DECISION DELEGATED TO HEAD OF PLANNING

Application No:	H23-0345-22	Applicant:	Mr & Mrs D Ford
Proposal:	Change of Use of Barn into Residential Dwelling		
Location:	Carters Farm Oxcroft Bank Shepeau Stow		
Terminal Date:	25th May 2022

GROUND FLOOR PLAN 1:100

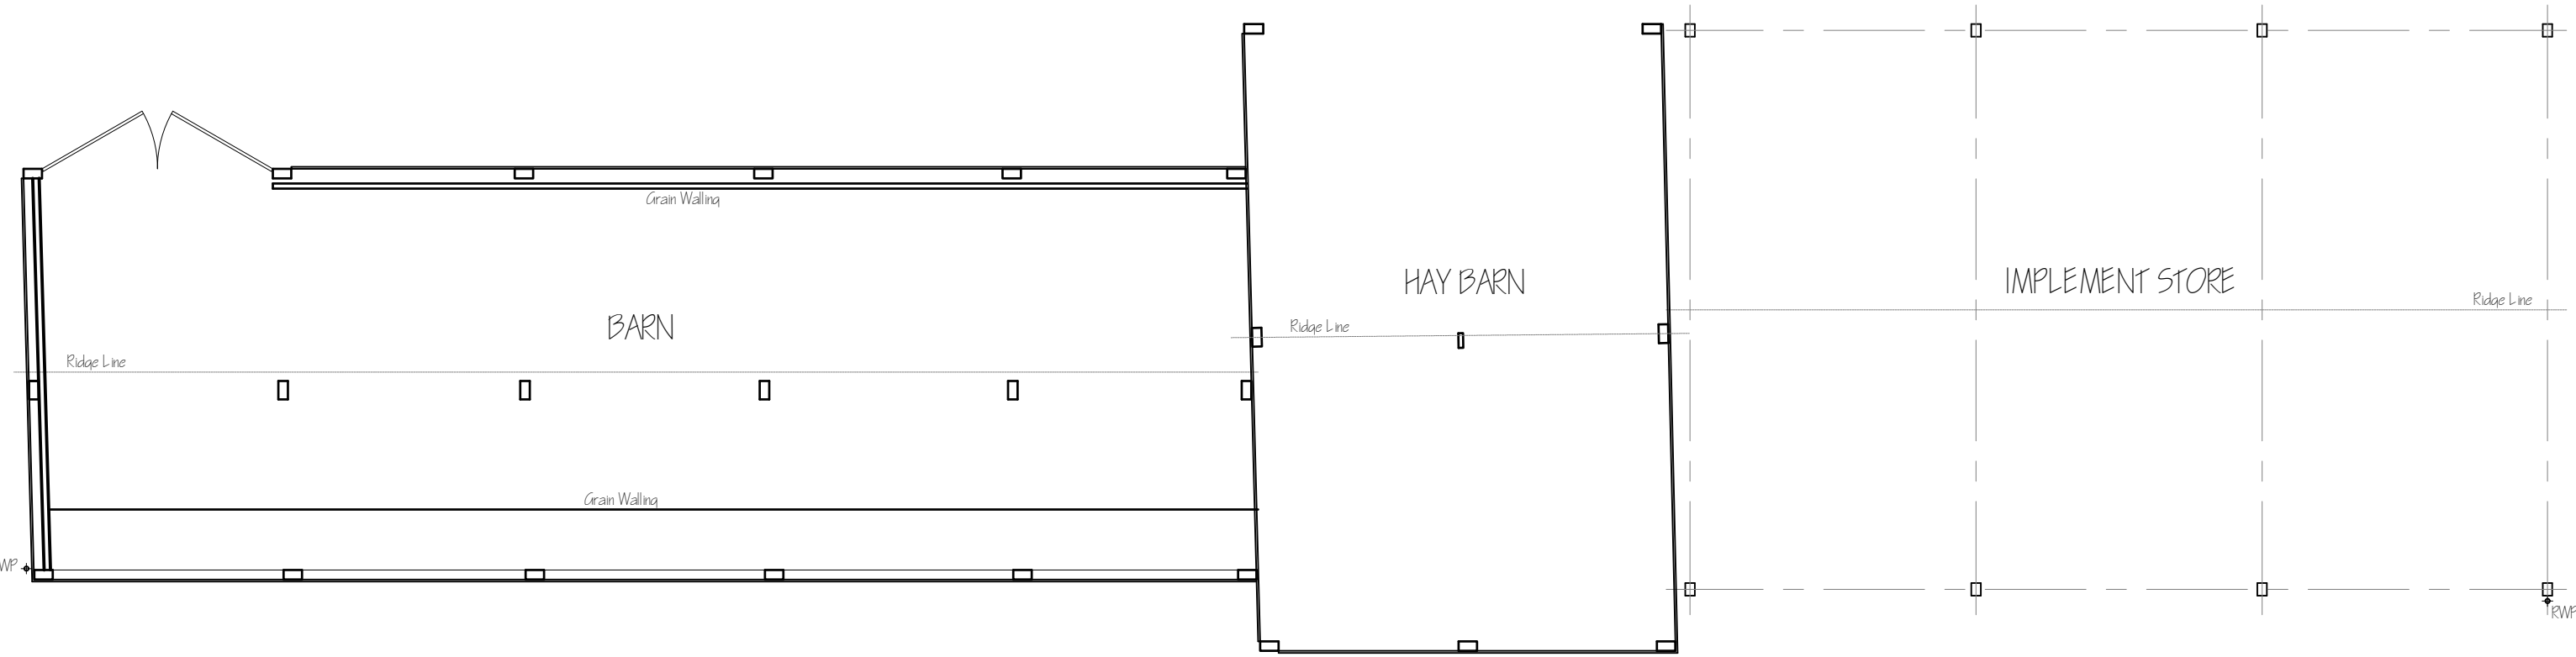
In this case it is noted that the existing framework is timber. The structural report accompanying the application indicates that the existing timber frame is inadequate for the proposed loads. The building is not considered to be capable of being converted to residential use without building operations that would be so extensive as to go well beyond the scope of the operations permitted by Class Q, and would amount either to substantial rebuilding of the pre-existing structure or, in effect, the creation of a new building.

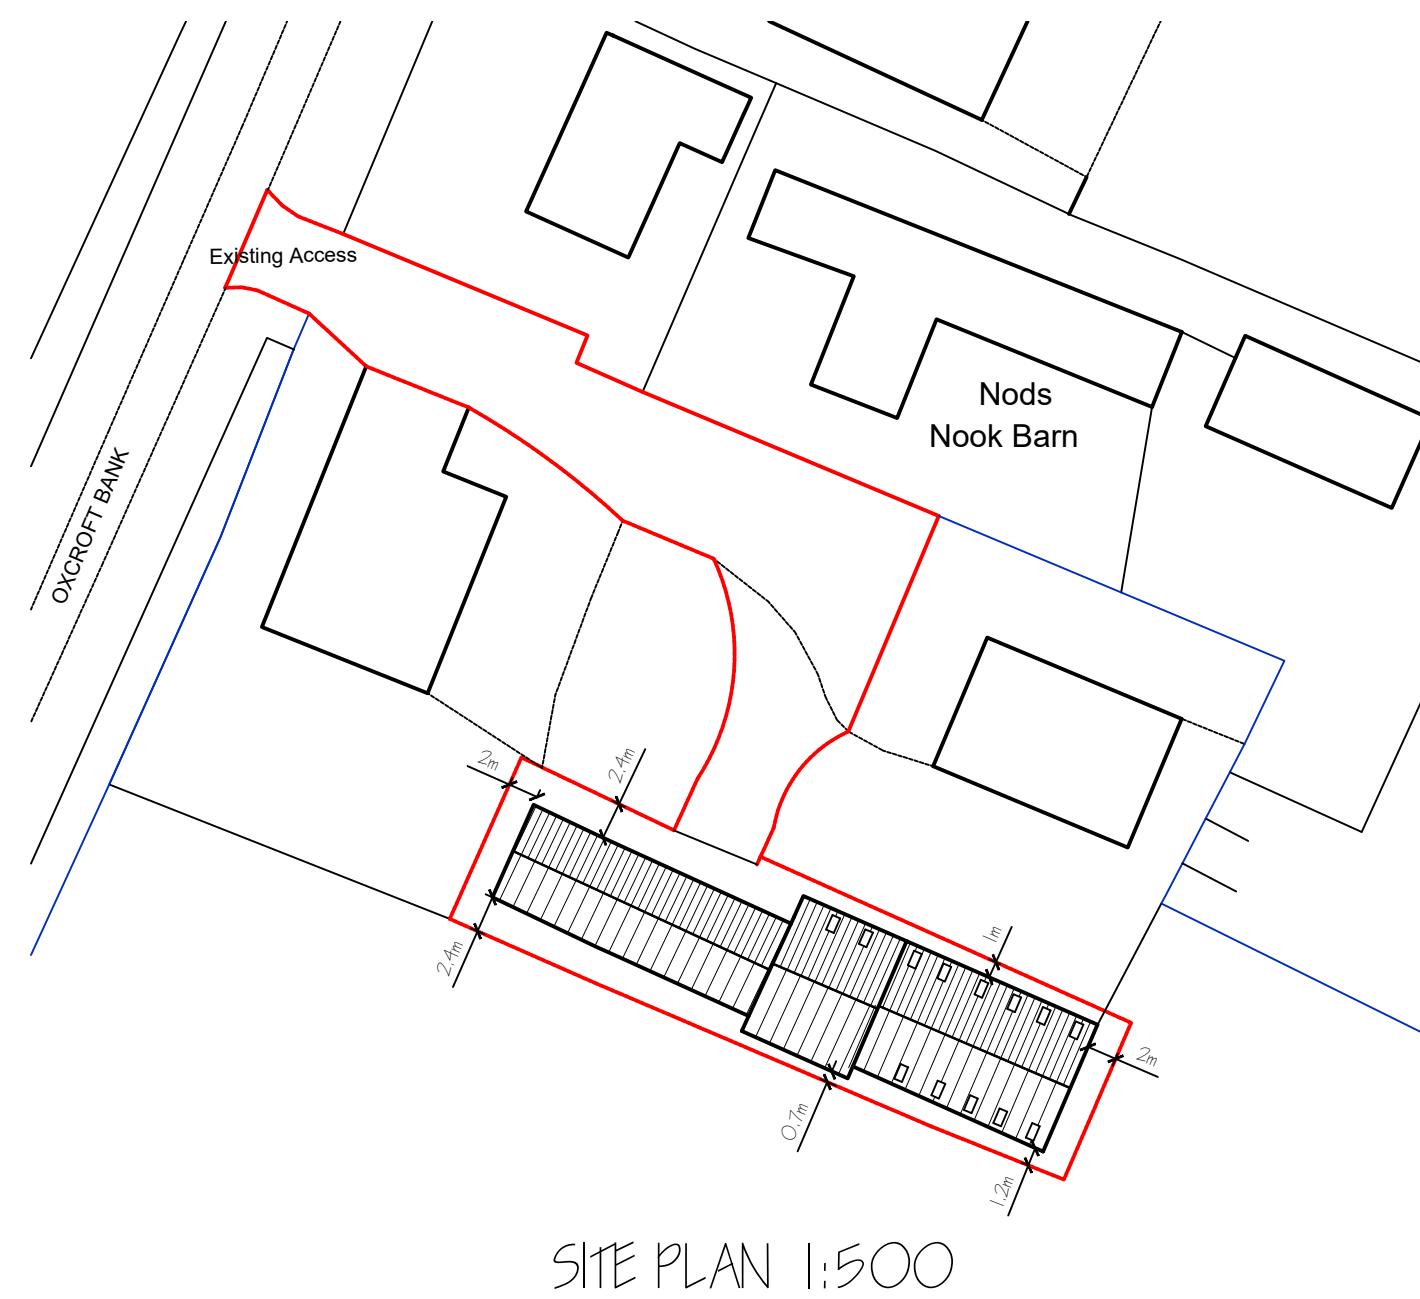
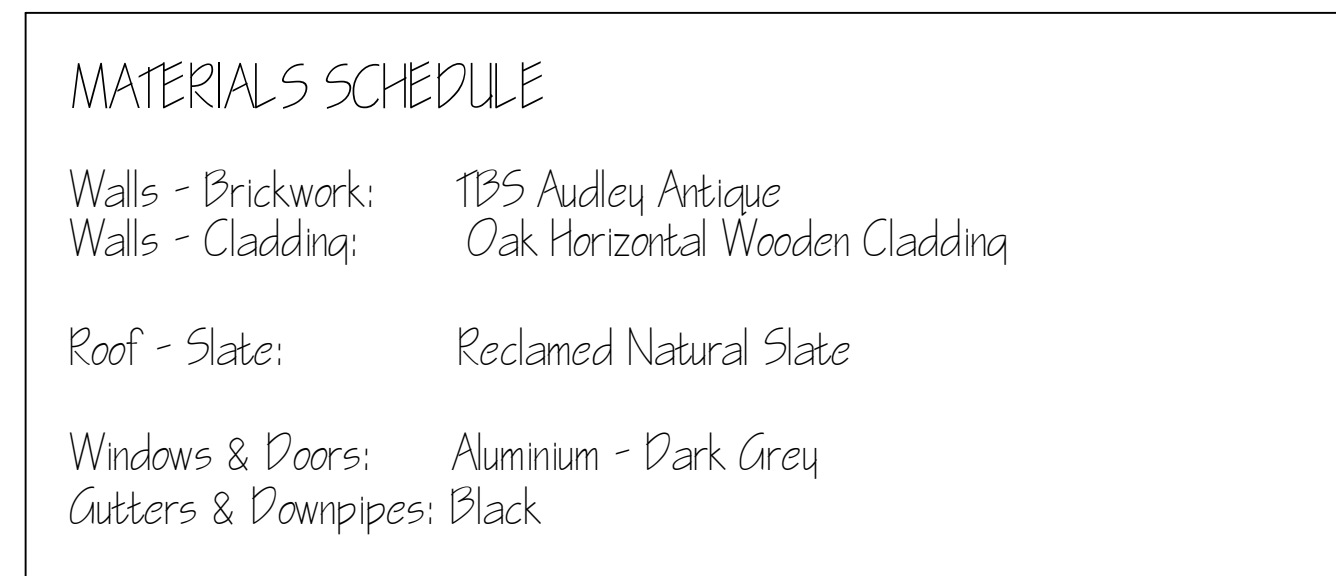
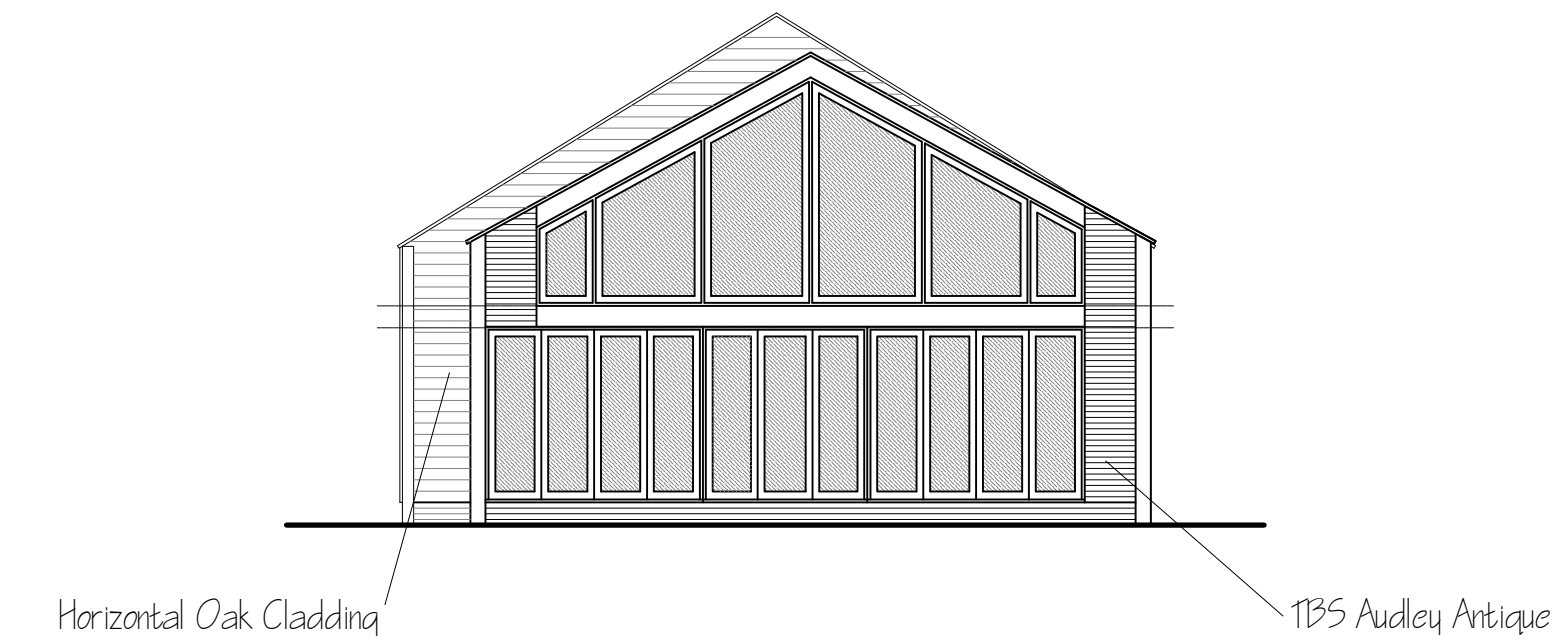
Moreover, the extent of works exceed that which is permissible under class Q which only permits minor works reasonably necessary to convert the building, and in particular the need to install a floor into the open element of the barns is not permitted under class Q. Neither is the complete creation of sides on a previous open barn - which go beyond the extent of class Q works.

Moreover, the extent of works exceed that which is permissible under class Q which only permits minor works reasonably necessary to convert the building. The installation of a floor into the open element of the barns and the creation of sides on a previous open barn go beyond the extent of Class Q.
